WEST SUSSEX COUNTY COUNCIL CONSULTATION

TO:	Arun District Council FAO: Anita Gardner
FROM:	WSCC - Highways Authority
DATE:	14 January 2020
LOCATION:	56-57 Pier Road Littlehampton BN17 5LP
SUBJECT:	LU/352/19/PL Extensions, alterations & new fire escape staircase to enable change of use from 1no. restaurant into 2no. restaurants (A3 - Restaurants & Cafes) & conversion of 1no. 5 bed flat into 2no. 3 bed flats.
DATE OF SITE VISIT:	n/a
RECOMMENDATION:	No Objection
S106 CONTRIBUTION TOTAL:	n/a / £ See below for breakdown.

West Sussex, PO22 8QH	
Tel: 01243 353076	
PROJECT DETAIL	
8055 BREZETZ RESTAURANT	
96-97 PIER ROAD, LITTLEHAMPTON	
WEST SUSSEX BN17 5AP	
CONVERSION	
FOR: MICHAEL KAWALEROS	
DRAWING	SCALE
PROPOSED ELEVATIONS	1/50
DATE: MAY 2019	
DRAWN: T. Murray	
DRAWING: 19/04/2	REVISION:

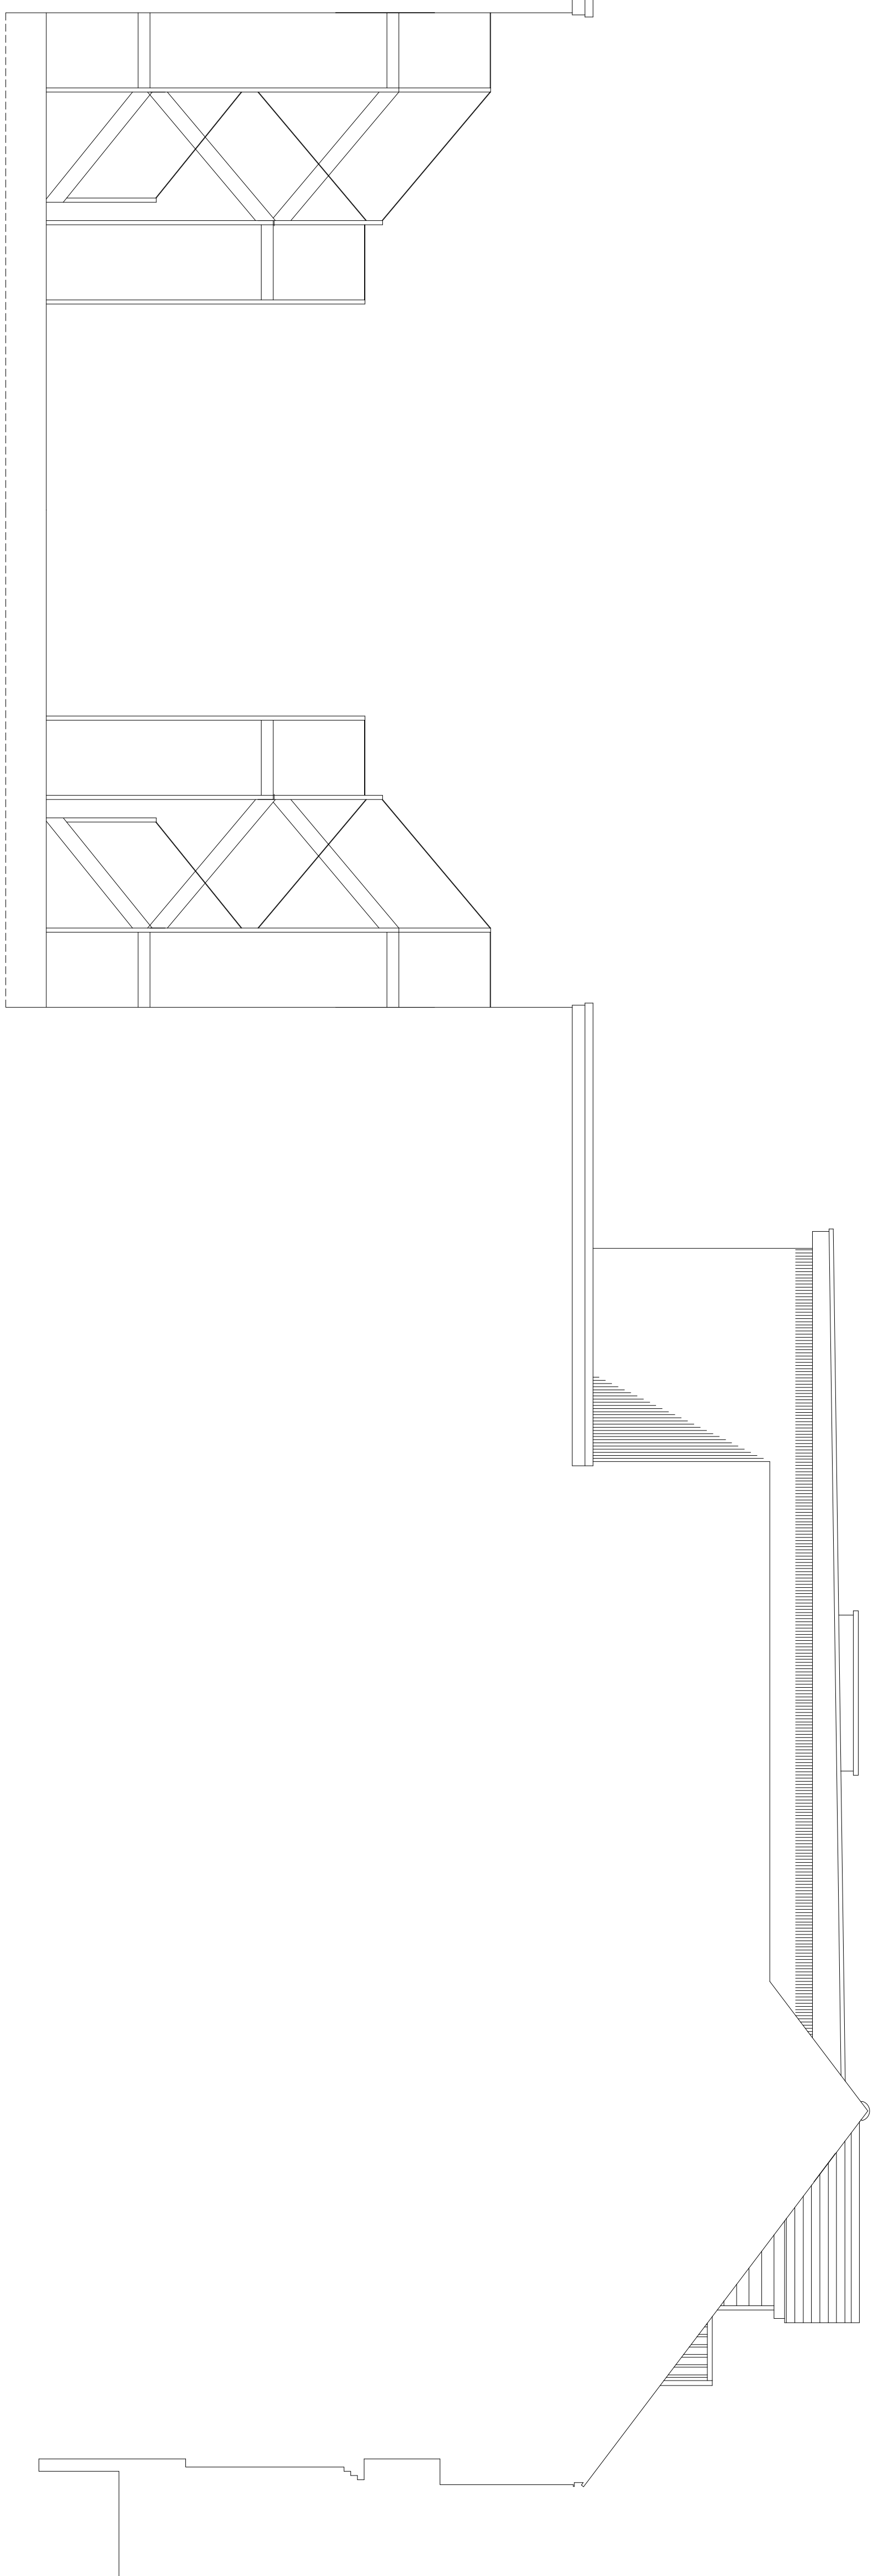
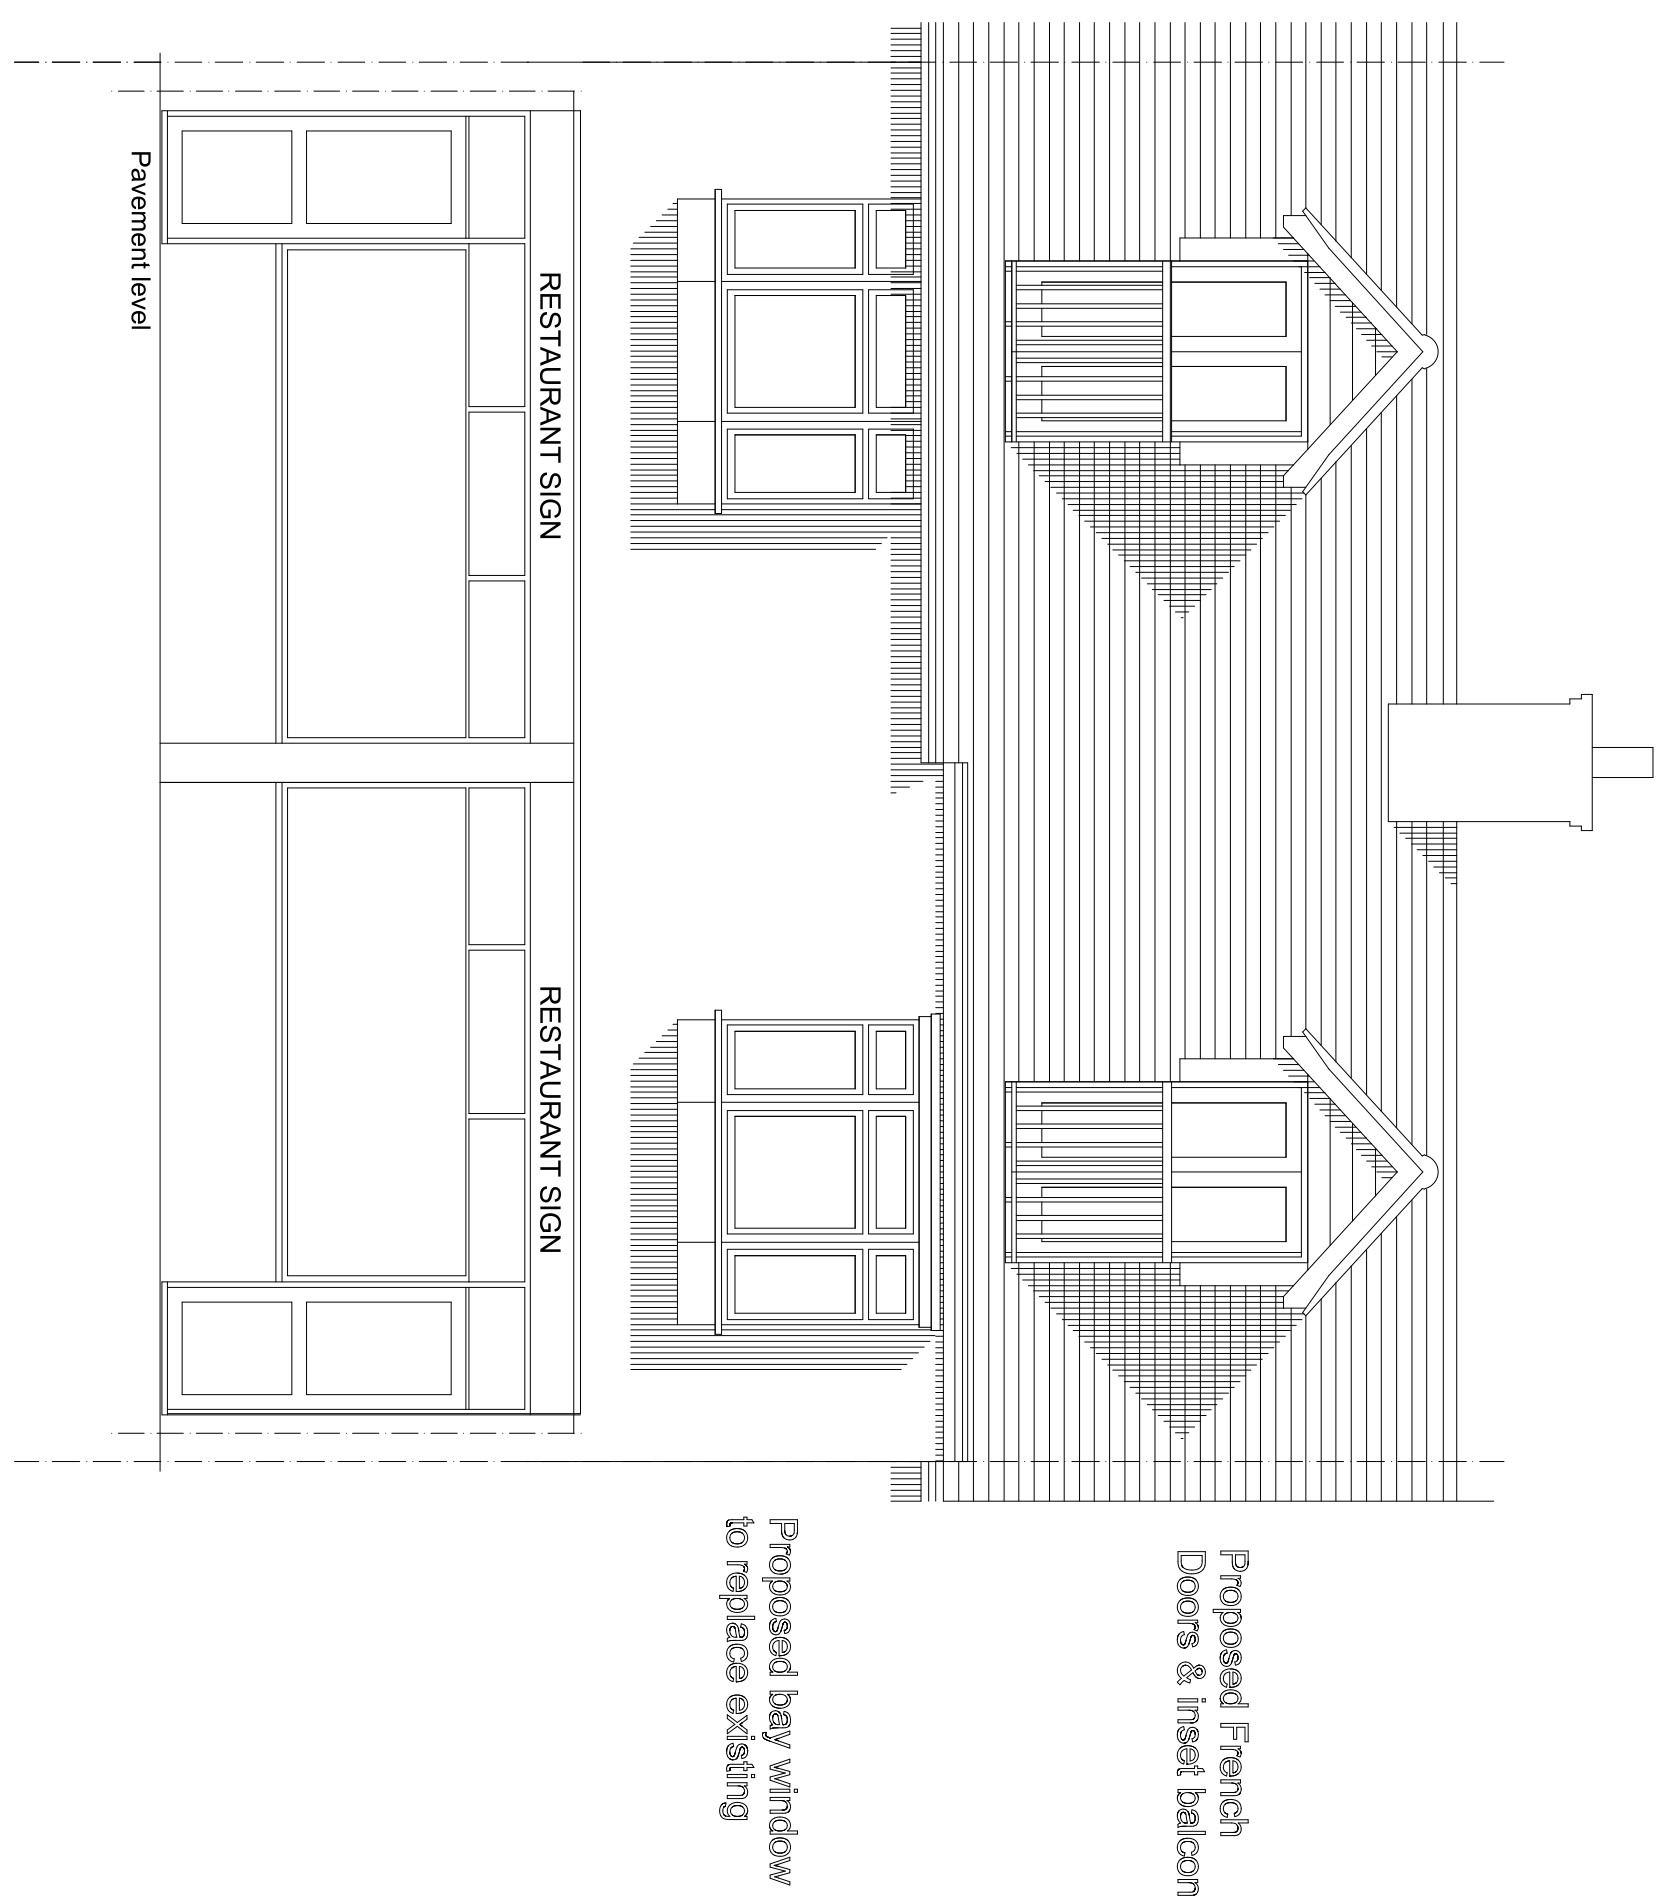
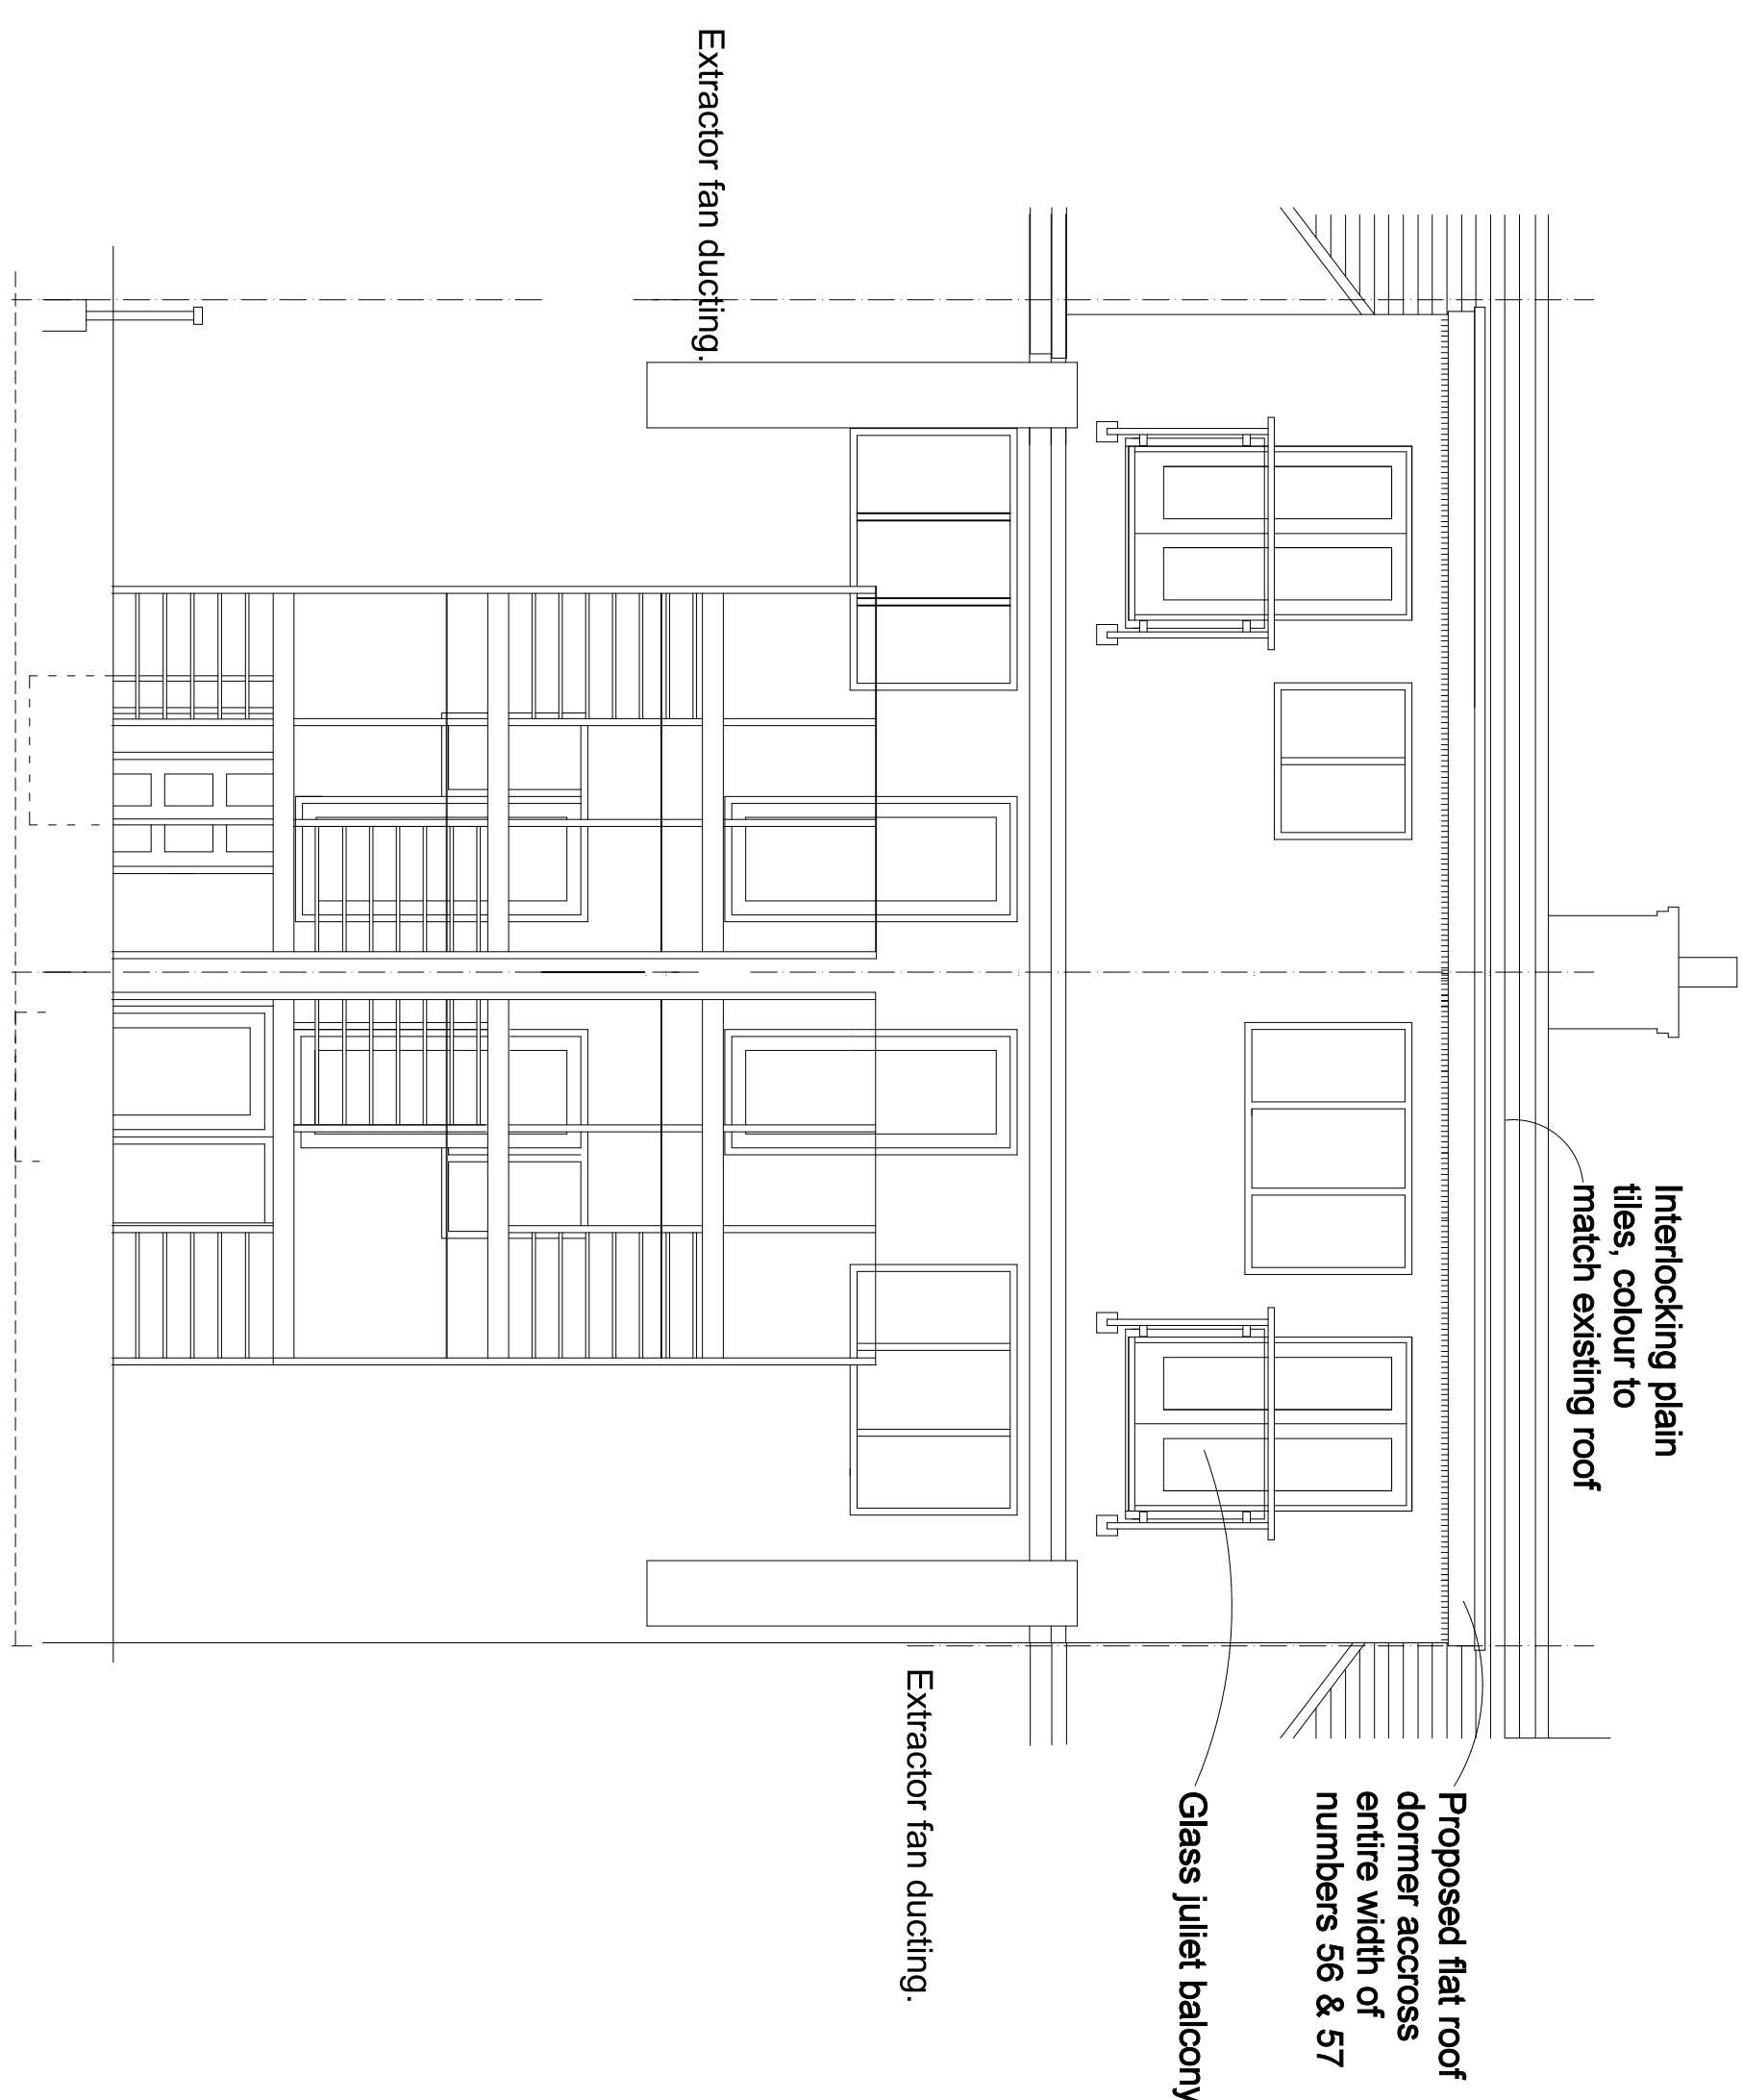
During the construction of the flats the need for scaffolding or heras fencing along the footway may be required (see CMP condition) and the applicant is urged to check if any temporary licenses are required. Additionally the proposed bay window may require an oversailing license, if it does not have one already, and because it may be different in size and hangs over the public highway. These are easily arranged through WSCC.
